918 Brighton Avenue | Portland, Maine 04102

January 3, 2013

**RE: Response to City Review Comments  
Level I Site Plan Development Review Application  
Motley Street Extension, Portland, Maine**

C3.0

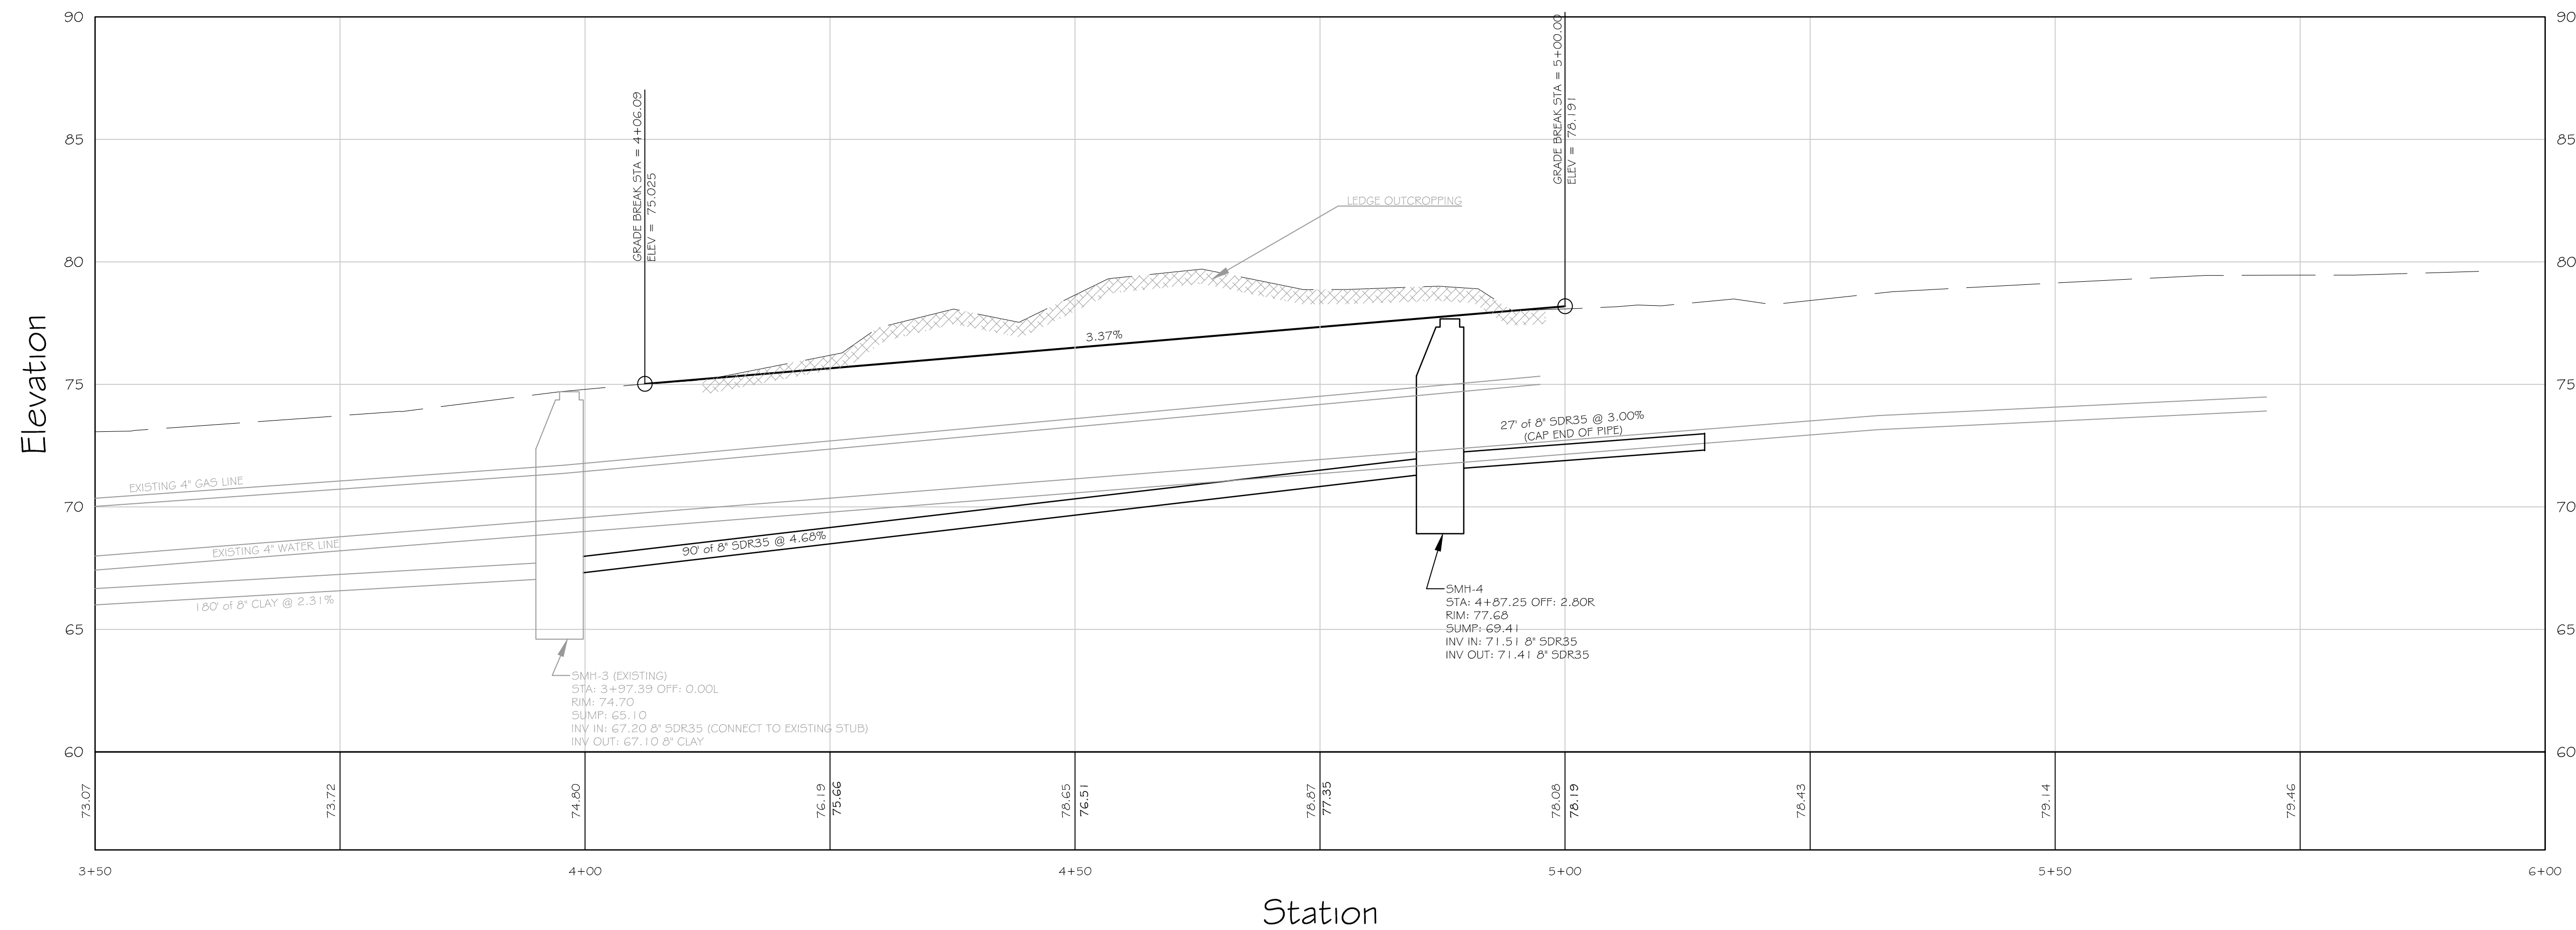
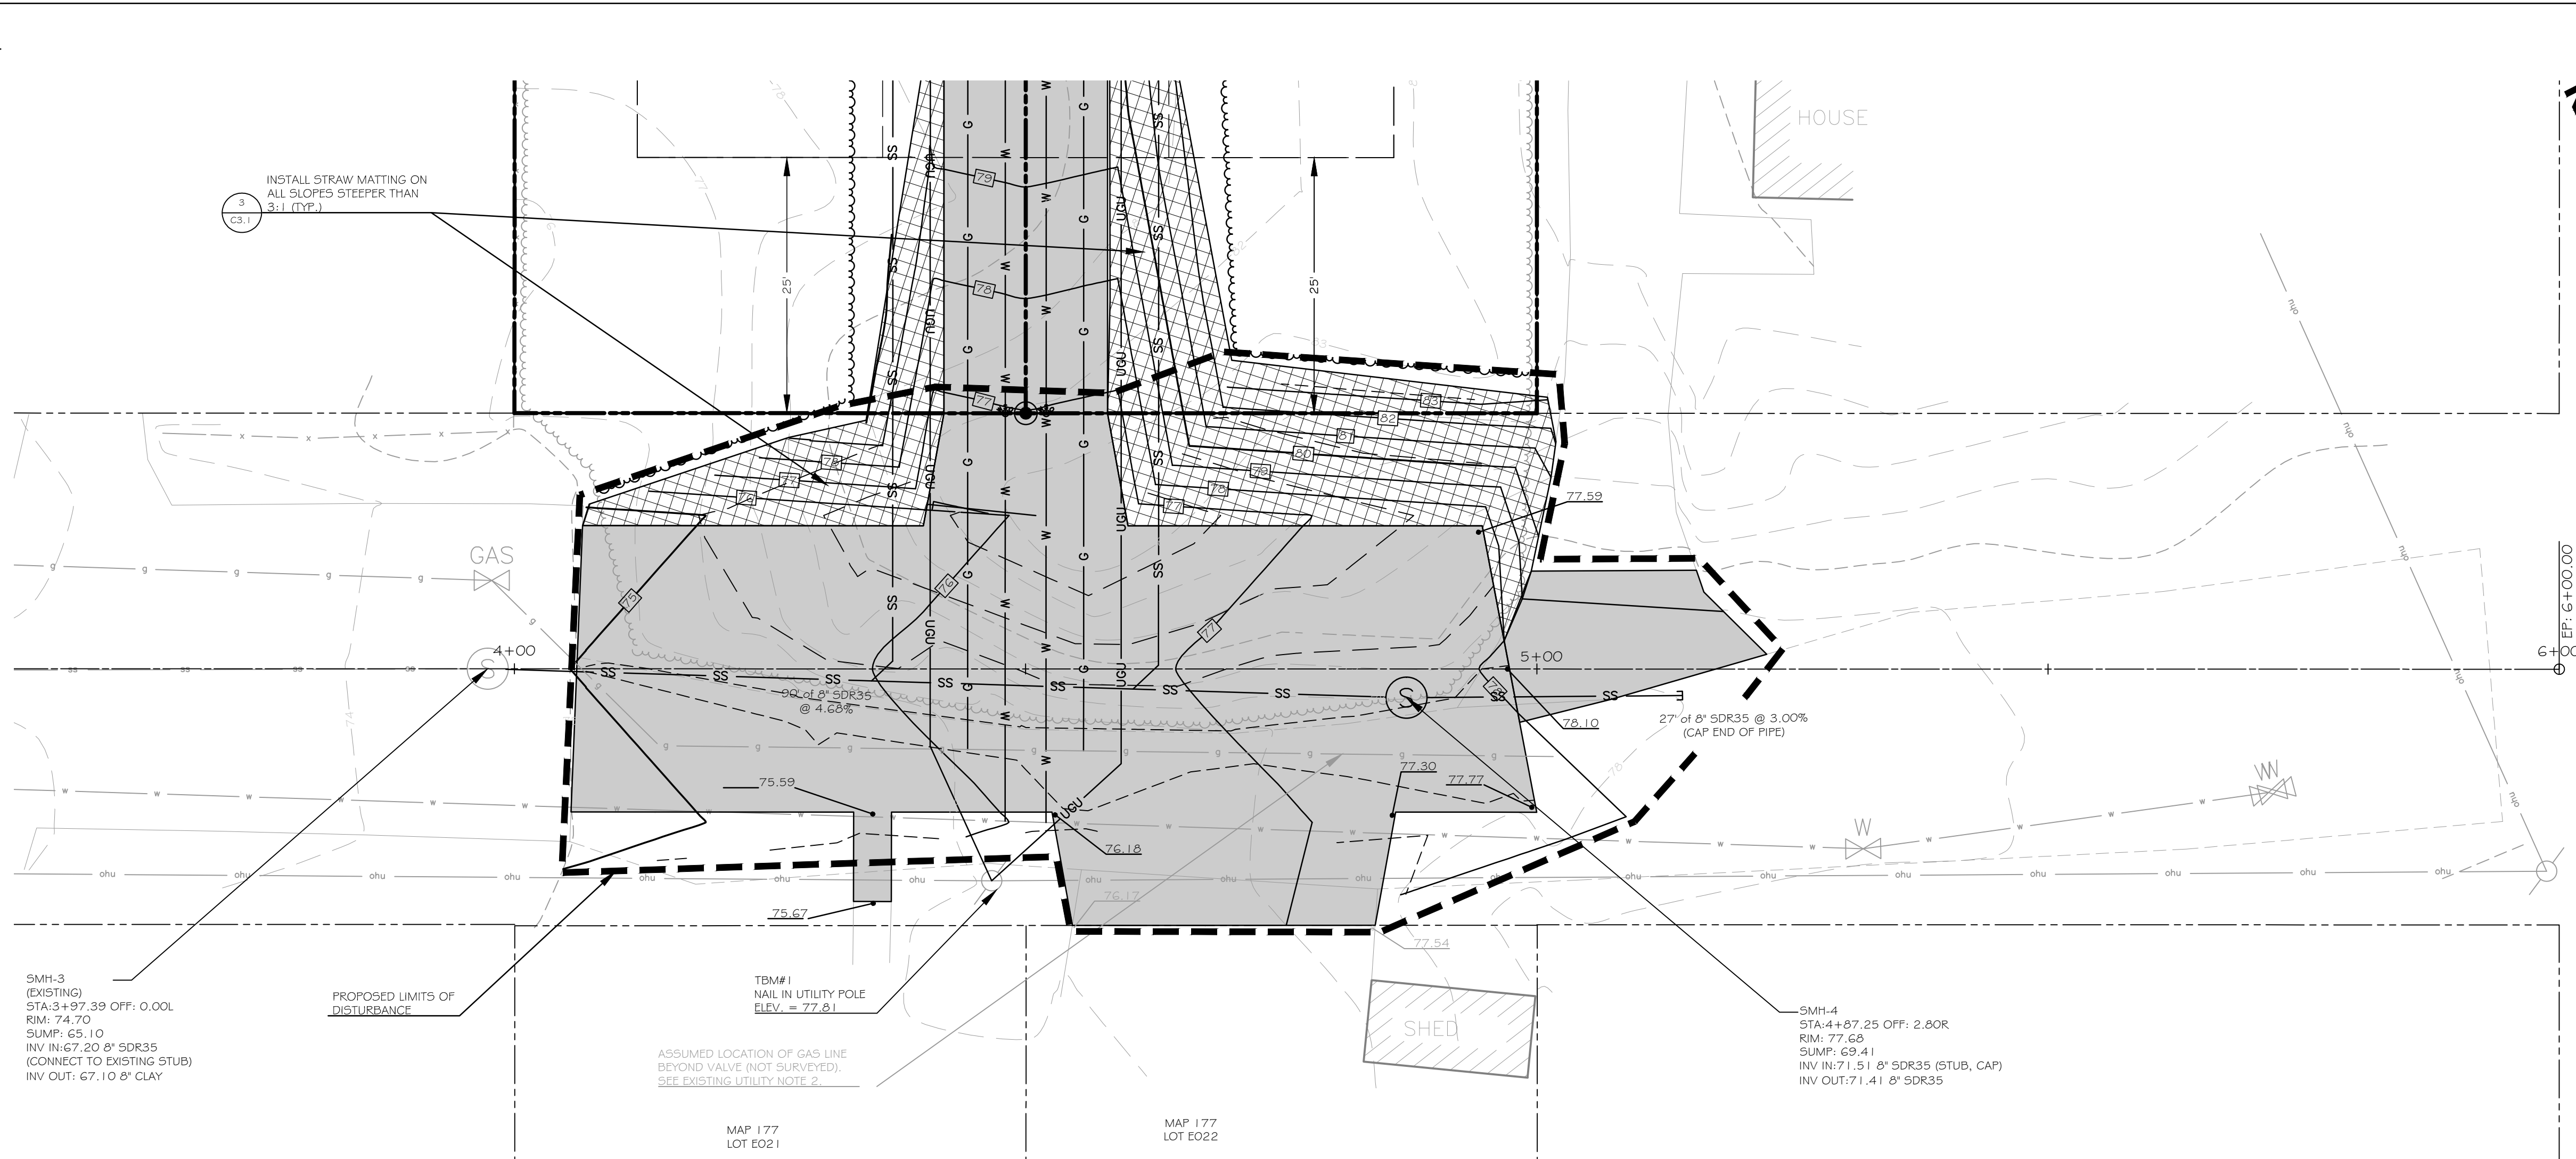
Walsh Engineering Associates, Inc. has reviewed section 3.7 of the City's Technical Manual and has added a note to sheets C.2.0, C2.1, and C3.0 that a blasting permit and all associated submittals will be required for a "large blast" operation (removal of greater than 300 c.y. of rock material).
